Change of pitched roofs to full gable roofs, new mono-pitch dormers to front & rear elevations on main dwelling, new gate, posts & fence to front of property site & change of existing annexe roof to split mono-pitch roof.

9 Myrtle Grove East Preston

Thank you for your internet representation made on 1st May 2019 which has been recorded as '**an objection**' with the comments as follows:

Drawing: 311 – Proposed Elev.'s N & W

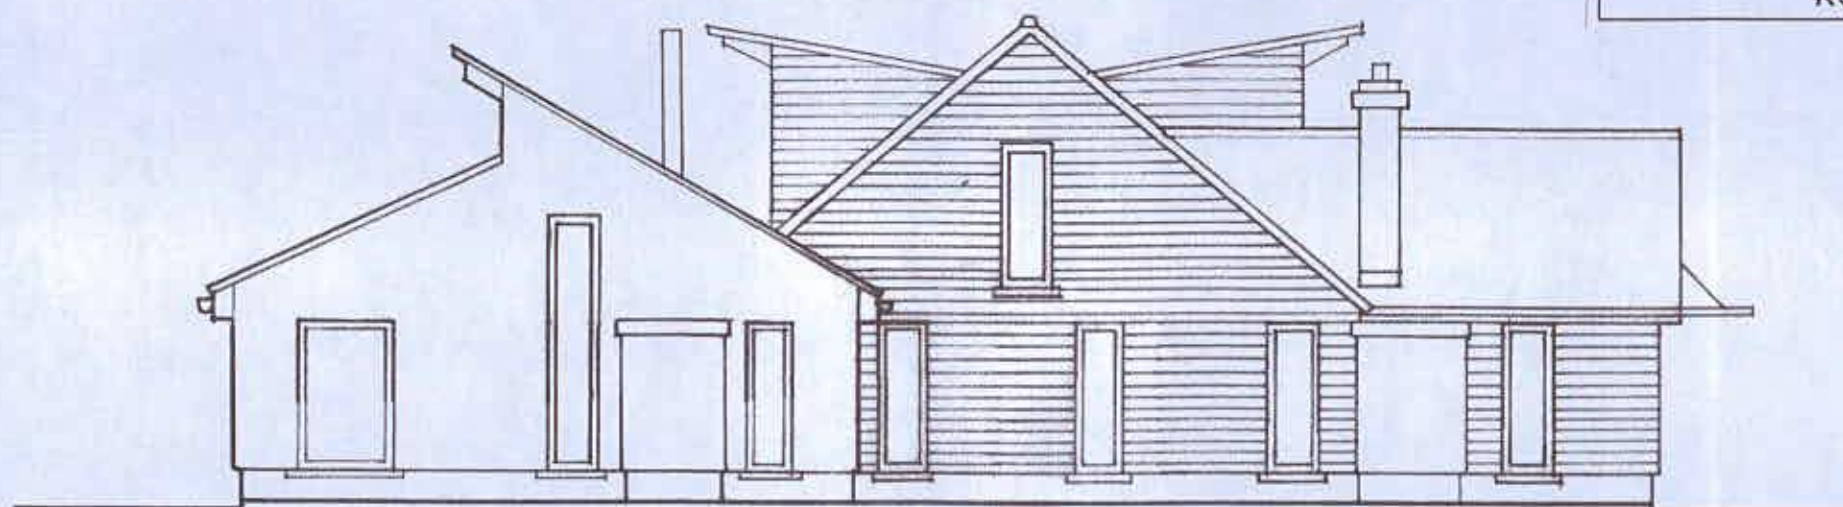
The proposed alterations would create a building that was dominated by large dormer windows, and finished in materials that are alien to its surroundings. The roof would be covered with dark grey slate effect tiles, with metal covering the dormers; walls would be dark grey brick plinths and wood cladding of unspecified colour. The dominant colour would be grey, in contrast to the reddish-brown of surrounding houses' The dormers would extend along almost the whole of the length of the roof on the northern side of the building, and about three-quarters of the length of the roof on the southern side. They would reach almost to the ridge of the roof, and are tilted upwards towards the window side, a feature that makes them all the more dominant. The original bungalow would completely disappear.

The design of this proposal appears to have been completed without any consideration of local planning policies. The huge dormers cannot be said to be visually integrated with the existing building, or visually subservient to it. The new materials of the roof and walls do not sympathetically relate to the materials of the existing house; they are a sharp contrast to its materials and to those of surrounding buildings. They create a building that contravenes policies D DM1 and D DM4 of the Arun Local Plan. It also contravenes Policy1 of the East Preston Neighbourhood Plan because the design and materials used do not reflect the character of surrounding buildings, and the dormers are not subservient to the appearance of the roof as a whole.
